Town and Country Planning Act 1990 (As amended)
Town and Country Planning (General Permitted development) Order 2015 Schedule 2 Part 1
Class A
Application for Prior Notification for a householder extension

Development Notification under extended permitted development rights for a single storey rear extension measuring 4m from beyond the rear wall of the original dwelling house, with maximum height of 3.2m and eaves height of 2.55m.

Location 103 Roundstone Drive East Preston

C918-3B

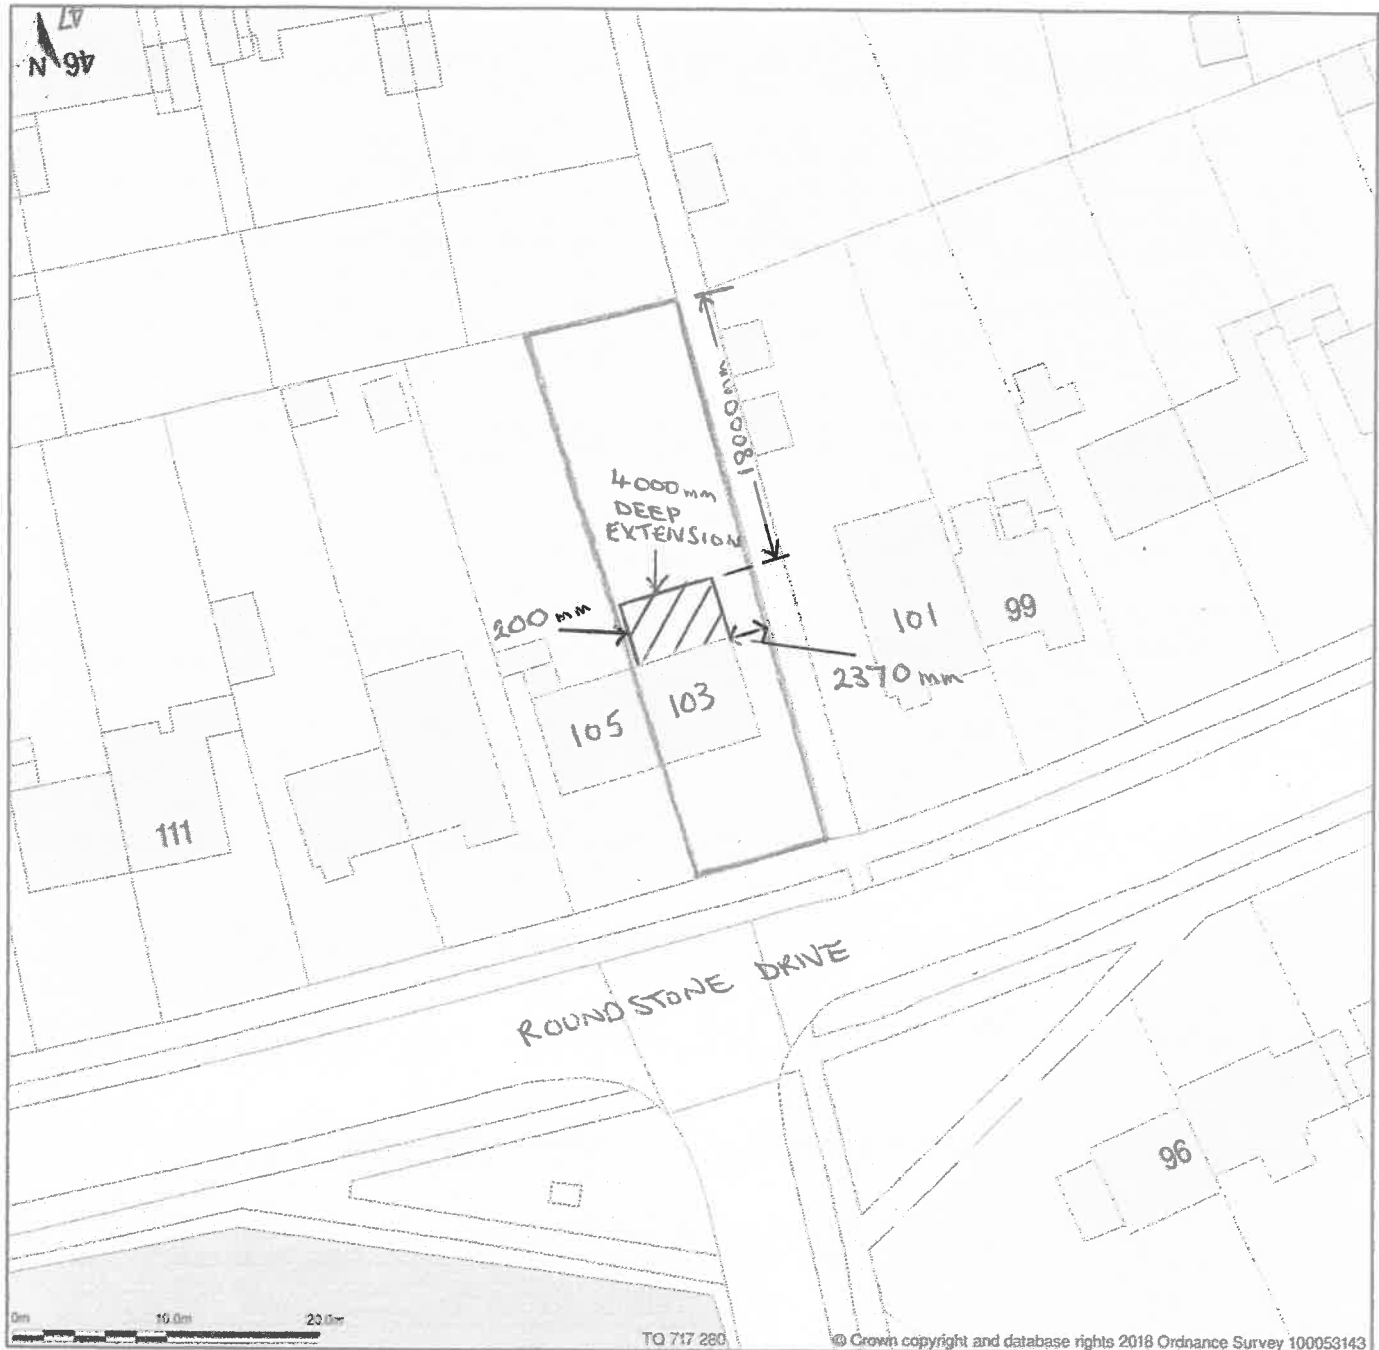
Please amend Block Plan to clearly show measurements to side and rear boundaries.
